This document has been provided in support of discharging planning condition 13.

The Phase 1, 3 & 4 Storage calculations (Ref: P3748) are based on a drained area of 0.71ha, a discharge rate of 71.2l/s (MH S18) and a storage volume of 114m² x 1.2m depth (i.e. 137m³) for the 1 in 100 year plus 30% storm (ref: Page 49). It is stated in the Drainage Statement that the discharge rate has been derived from the combined areas of MA1, MA3 and the future MA4 buildings.

Client: T.C. Checked: S.A.B. Date: Sept 2022 Issue: 1:250 Digital only size: A0
Drawing Name: DBS-AVE-00-XX-DR-C-1006 No: P01

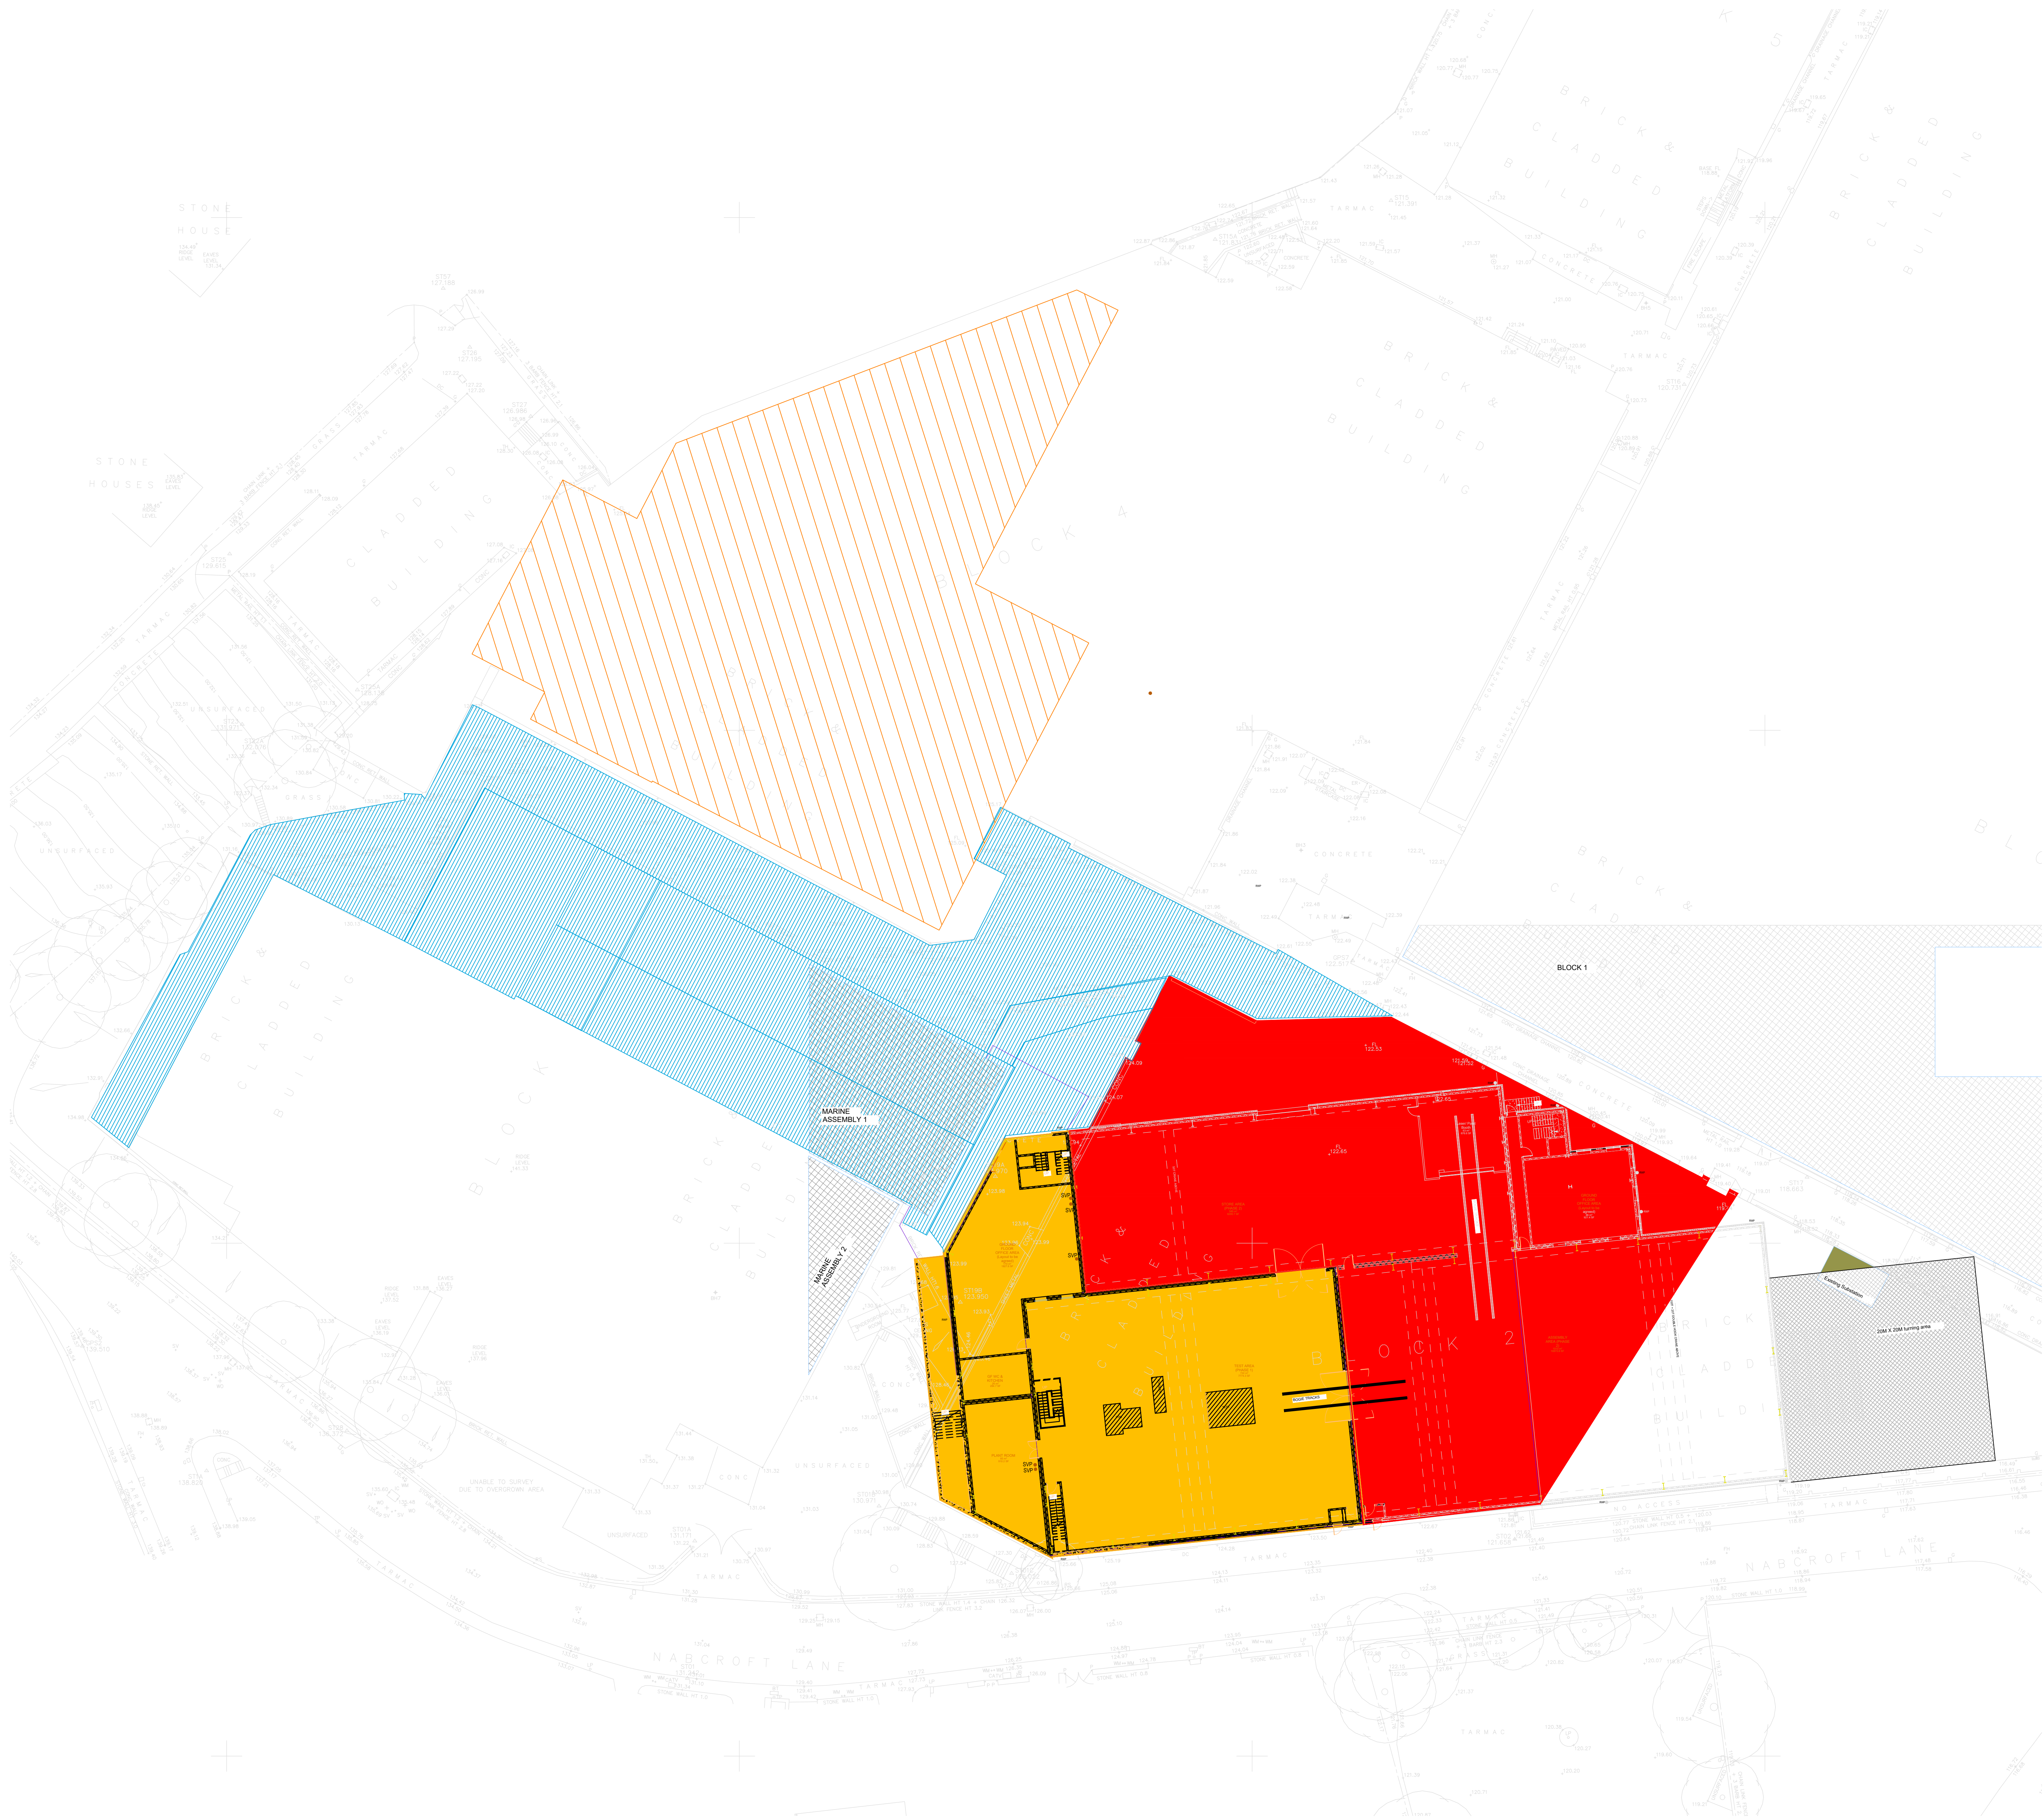
Drawing DBS-AVE-00-XX-DR-C-1006 has a shaded area described as “MA1 Contributing area” but the shading has not appeared on the drawing.

The area used to derive the 71.2l/s discharge rate shown on Drawing DBS-AVE-00-XX-DR-C-0005 is different to the Proposed Impermeable Area shown on DBS-AVE-00-XX-DR-C-1006 (0.949ha) – this discrepancy should be explained further.

Latest drainage layout indicates all contributing areas and further breaks down the impermeable areas for the new phase (Phase 4) specifying the pipe conduits the surface water flows will enter.

The discrepancy derives from Marine Assembly 1 area featuring twice in the key. The total impermeable areas for the purpose of calculating the existing surface water runoff rate equates to 0.727Ha. The drawing has been updated now and the final discharge rate has been amended to 70.7L/s considering a 30% reduction.

Drawn: P.A.S. Checked: S.A.B. Date: Aug 2020 Scale: 1:200 Original Issue No: AO
 Drawing Name: DBS-AVE-00-XX-DR-C-0001 No: C17

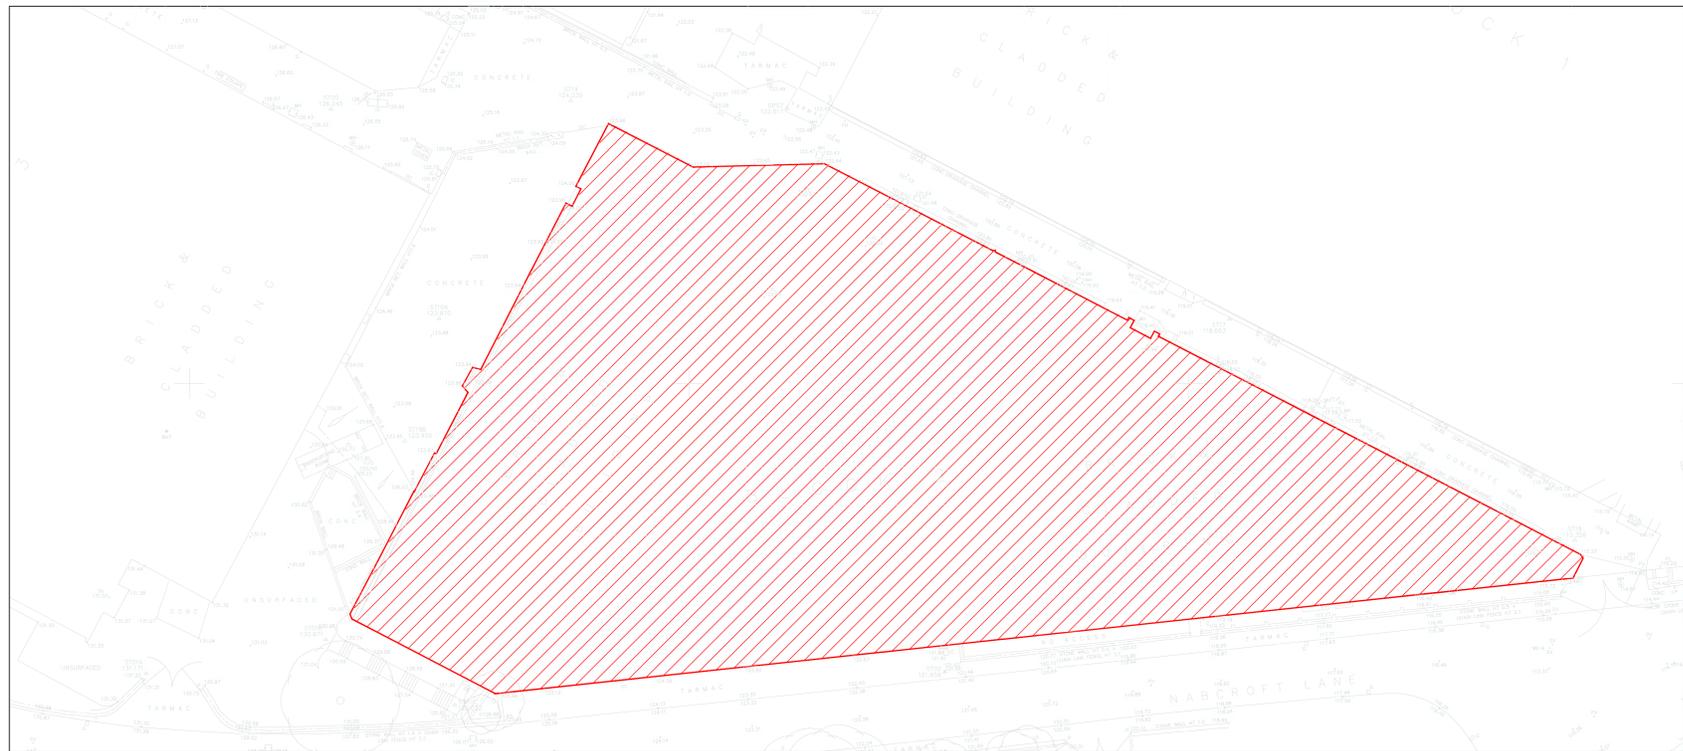
Drawing DBS-AVE-00-XX-DR-C-0005 appears to indicate that the area to be demolished is 0.292ha and partially replaced by the new MA4 building – what will happen to the remaining demolished area that is outside of the new building? Is it proposed that this area will drain unattenuated?

The latest drainage layout DBS-AVE-00-XX-DR-C-001 P05 indicates the proposals for the removal of surface water flows from the surrounding hardstanding areas. The method for removing the surface water runoff from the hardstanding areas will be with the use of linear drainage channels. All surface water runoff is attenuated and restricted at the discharge rate of 71.2L/s.
